167 Fore Street – Ocean Gateway Garage Addition

April 23, 2019

Amendment

Level II Site Plan Application

JOHNSON & JORDAN
MECHANICAL CONTRACTORS
 18 MUSSEY ROAD
 SCARBOROUGH, ME 04074
 TEL: (207) 883-8345

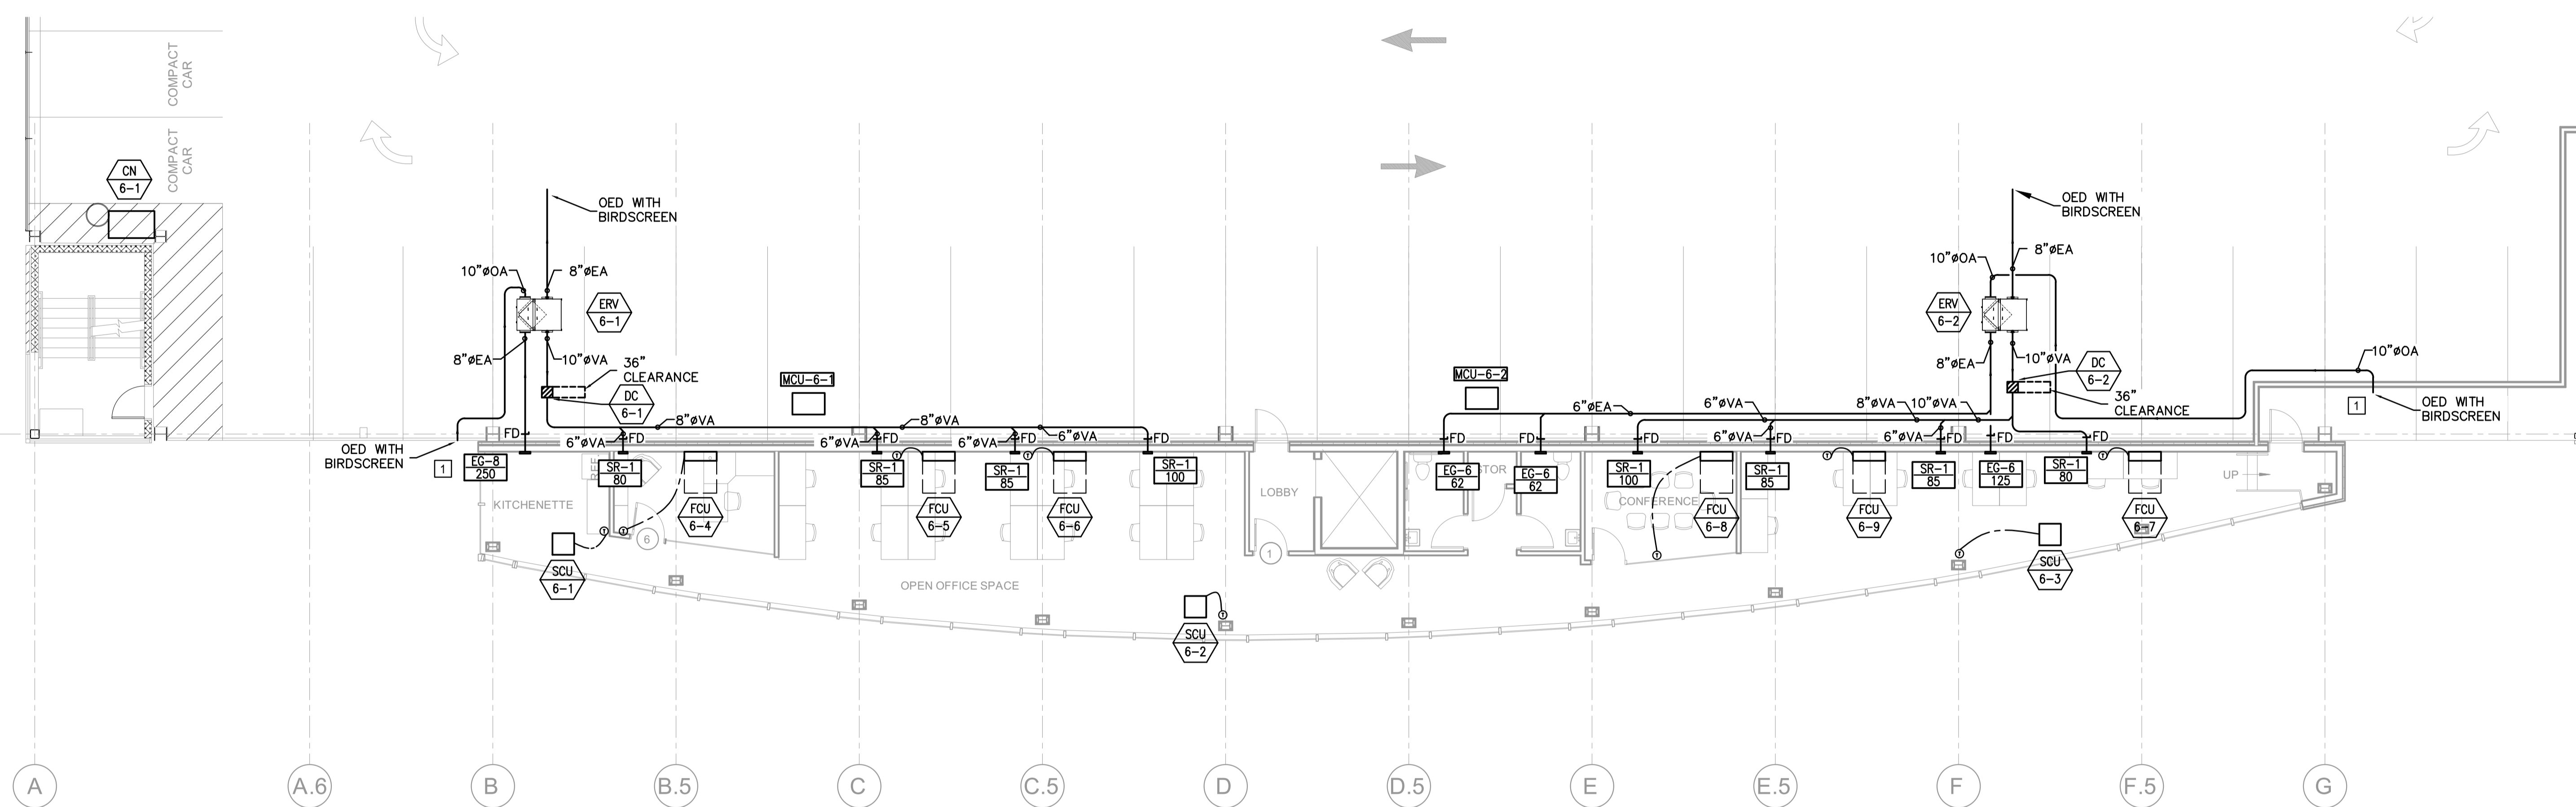
The attached plans (revised site plan and mechanical plans) demonstrate the amendment to the HVAC design as part of the original Level II Site Plan application for the Ocean Gateway Garage Addition at 167 Fore Street.

The original design intent was for the HVAC units to be located within a parking spot, typical of each level. Due to site constraints and parking requirements/lease agreements filed with the city, the location of these HVAC units was revised and resubmitted. The locations shown on the attached drawings represent the only feasible location within the existing garage layout, and all units are kept internal to the garage structure, not visible to the surrounding neighborhood.

All units are being treated and wrapped with sound attenuation material to help mitigate any sound or vibration and eliminate this concern.
